Case Officer: Wayne Campbell

Recommendation: Approve

Proposal: Demolition of the existing dwellinghouse and the erection of a replacement dwellinghouse

Title
Planning
Proposed
Pool House

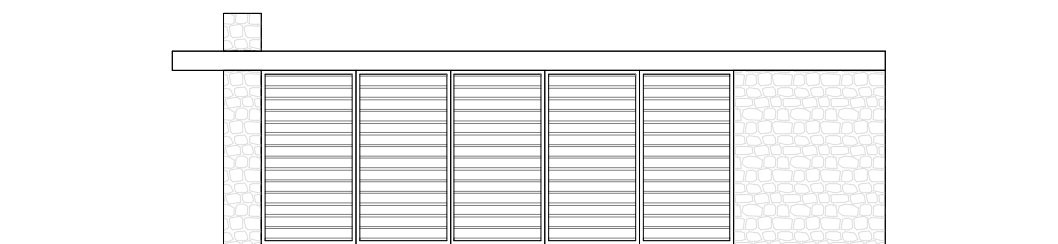
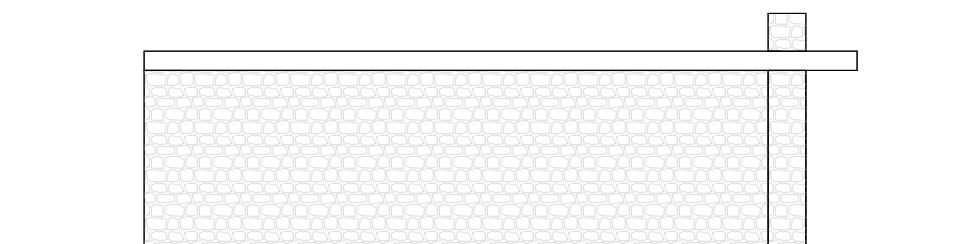
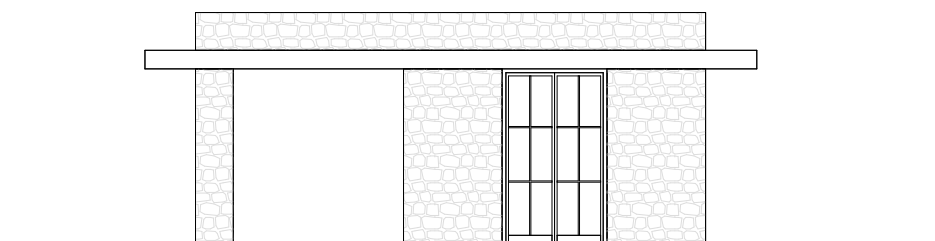
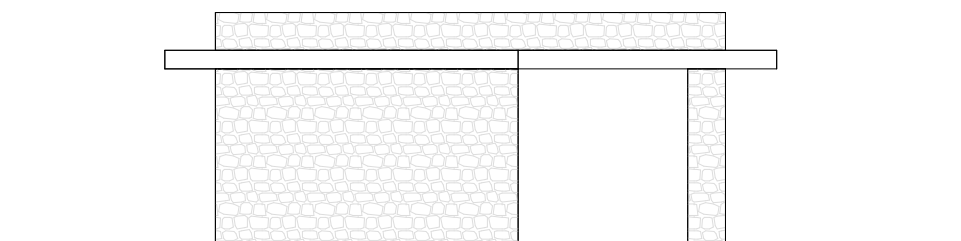
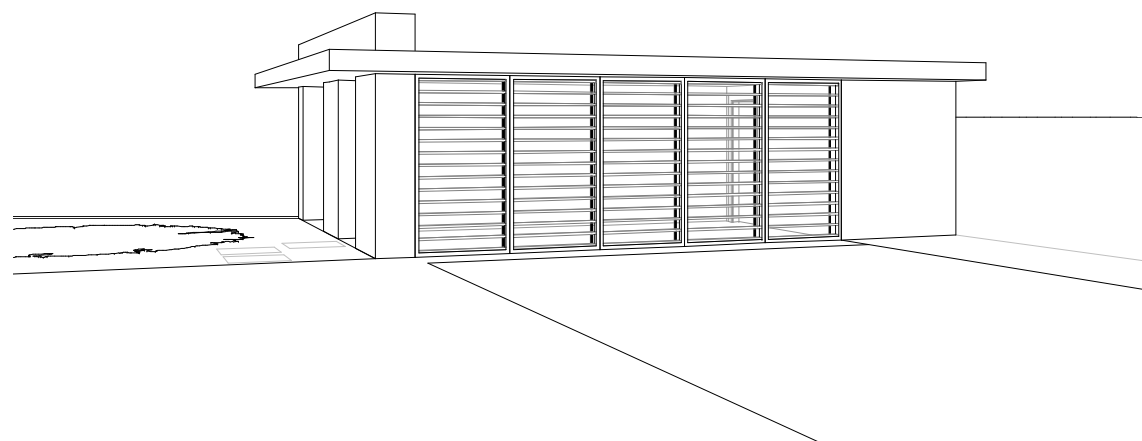
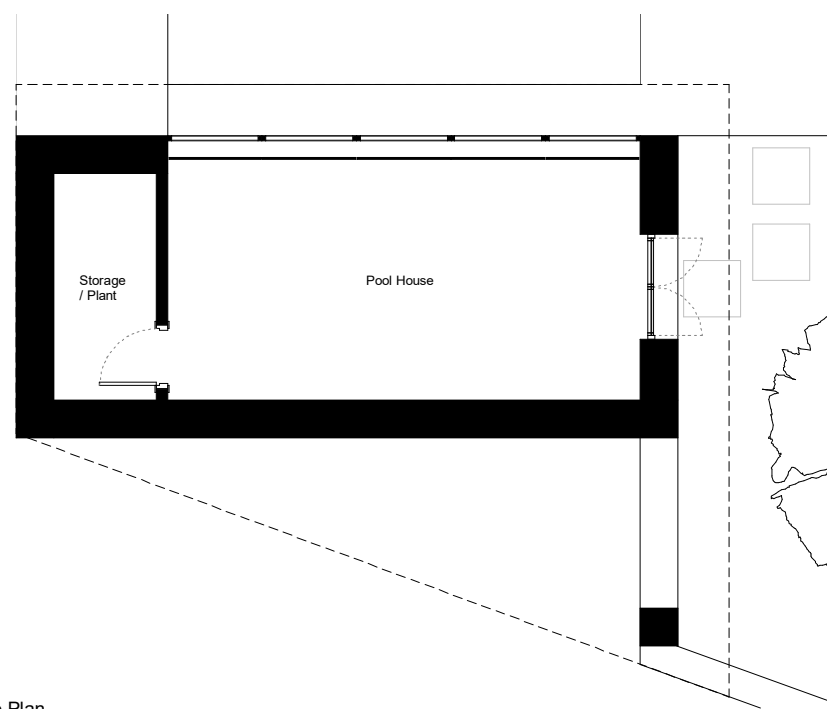
The final part of the proposal is for the provision of a surface level swimming pool along with a pool house to be located within an area of lawn to the front of the dwelling. The area of the swimming pool is the private garden area for the dwelling

and is maintained as a flat lawn with a number of small trees and hedgerow around the boundary. The proposal is for the surface level pool to be built which will be positioned on a north – south alignment. Although this would result in further development projecting forward of the main dwelling, and outside of the residential curtilage of the dwelling, the visual impact of this element would be minimal and would not adversely impact on the character or appearance of the area.
